EL PASO COUNTY STORMWATER MANAGEMENT PLAN CHECKLIST

Revised 5/21/07

P03 PROJECT NO. PPR-17-033

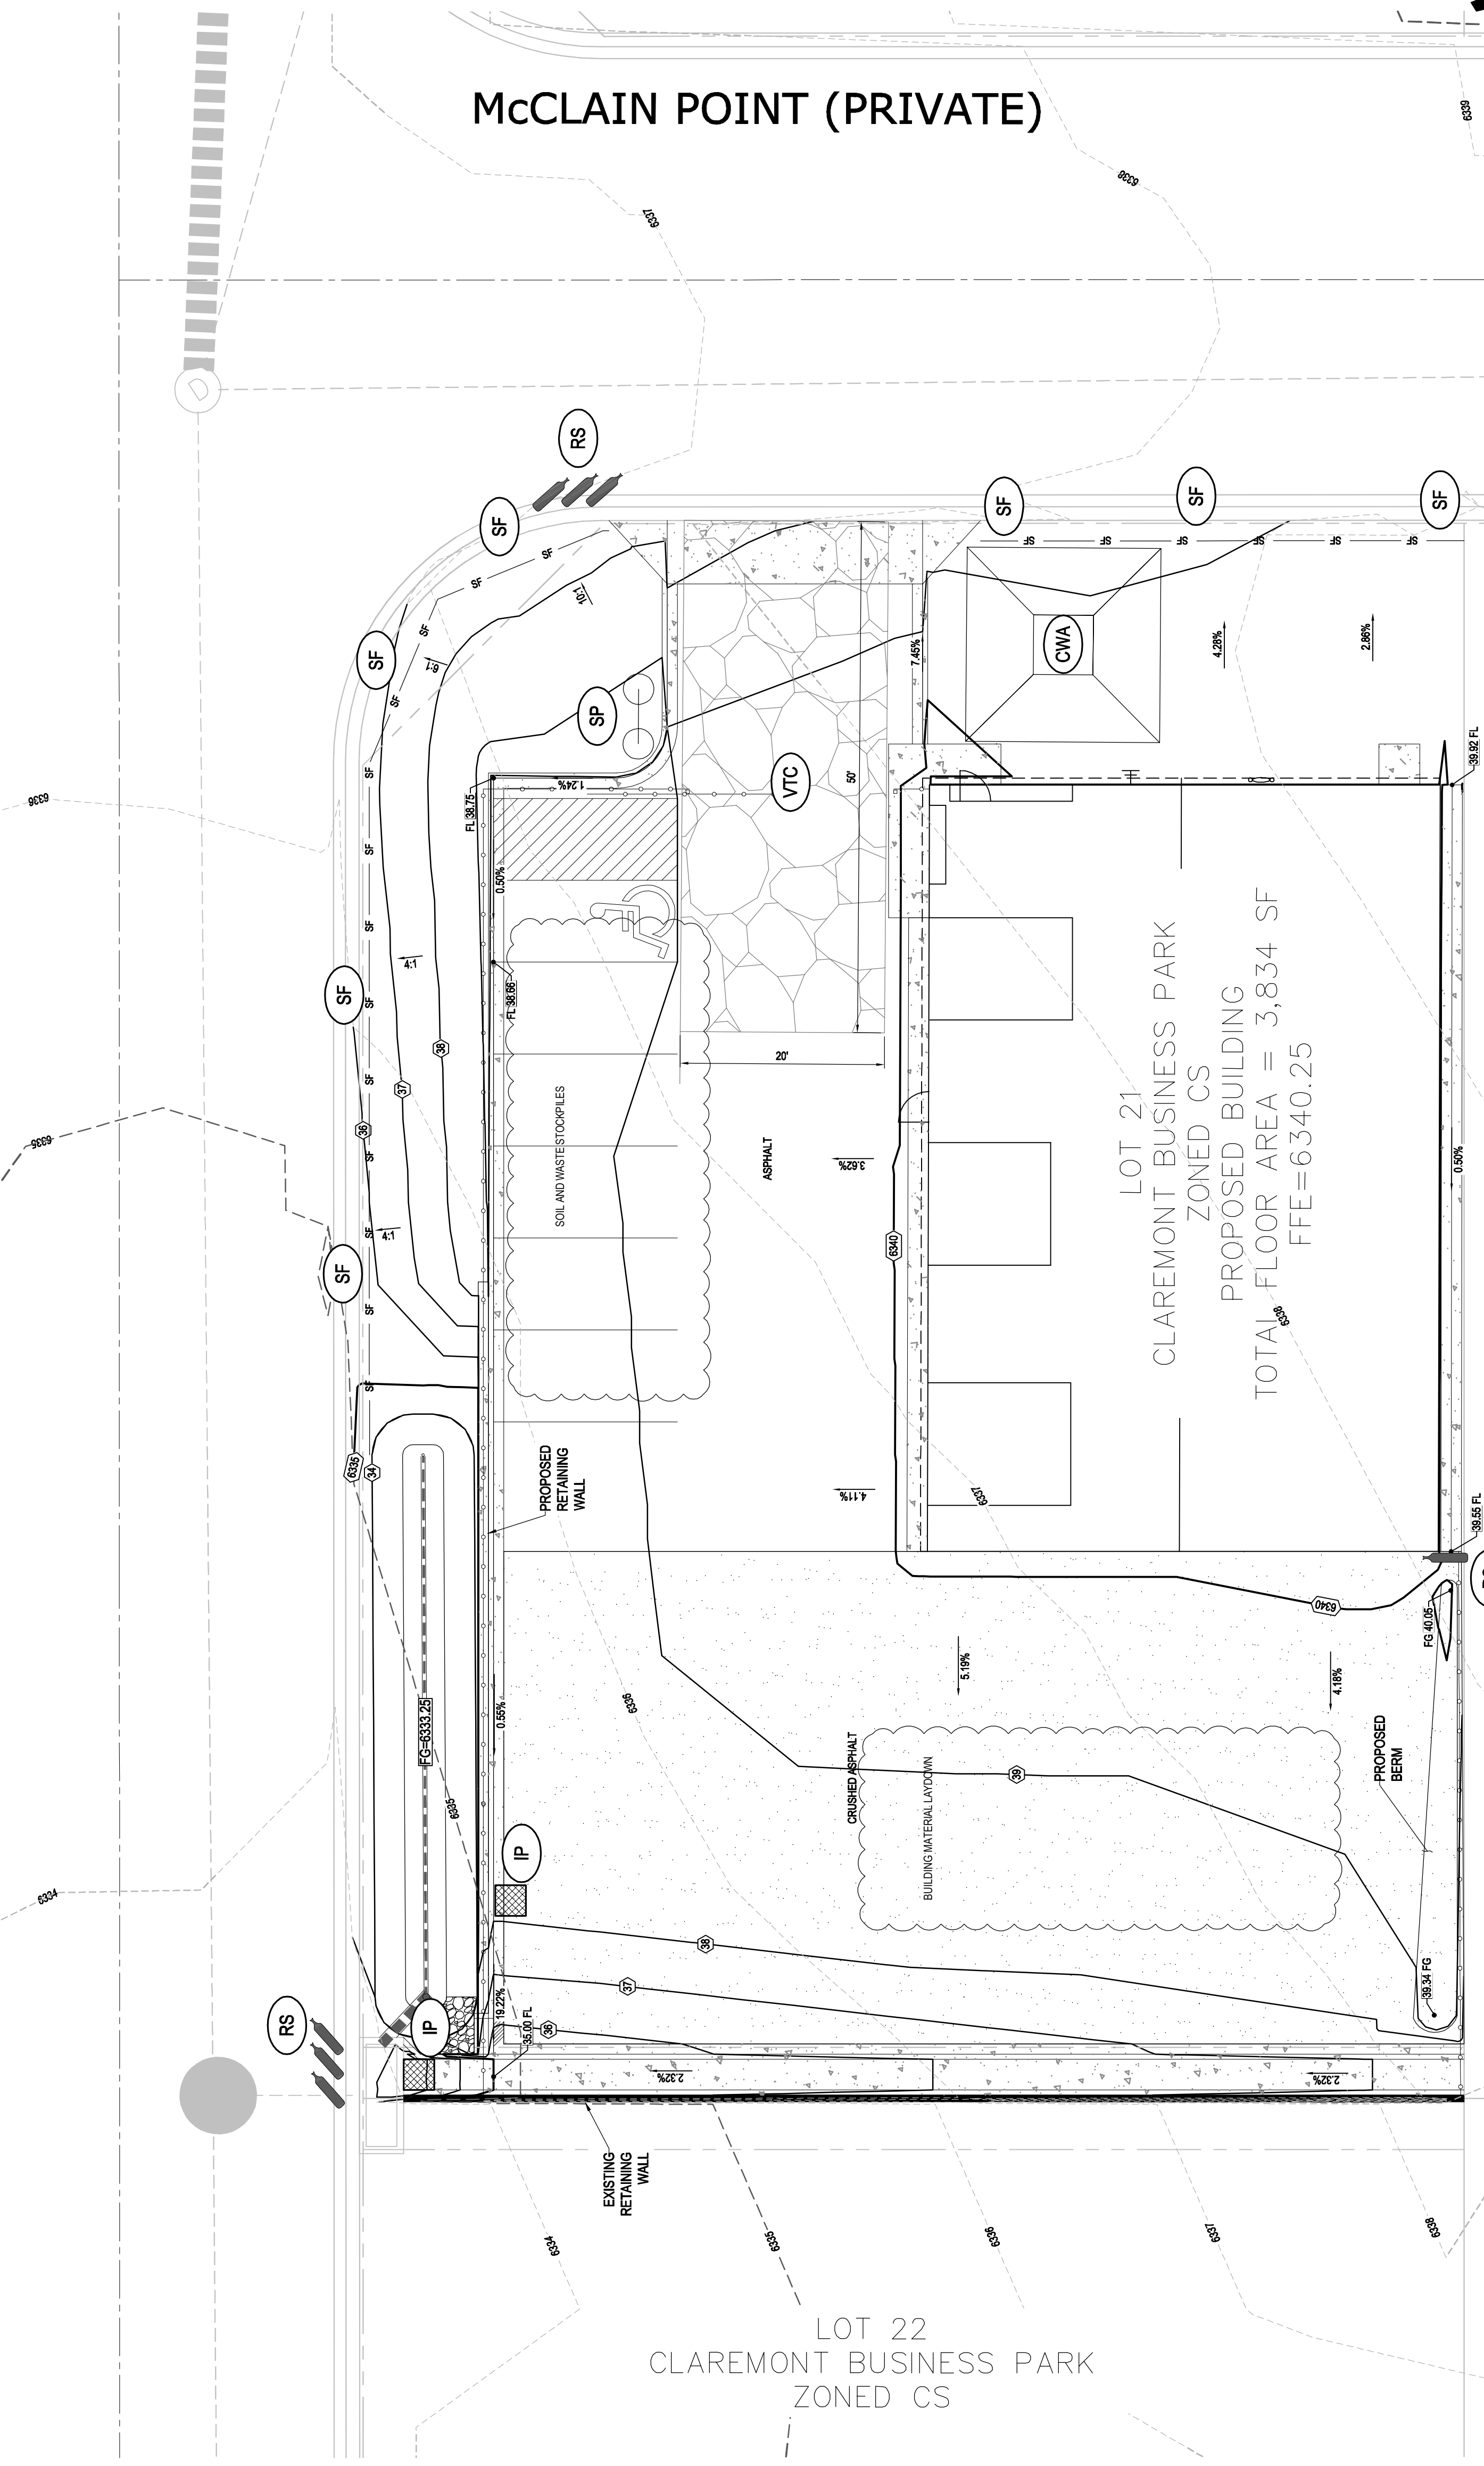
Add Section, Township, Range

Missing the percent ground cover.

- b) all areas of disturbance
 - c) areas of cut and fill
 - d) areas used for storage of building materials, soils or wastes (stockpiles)
→
 - e) location of any dedicated asphalt / concrete batch plants
→ See the note below regarding not applicable items.
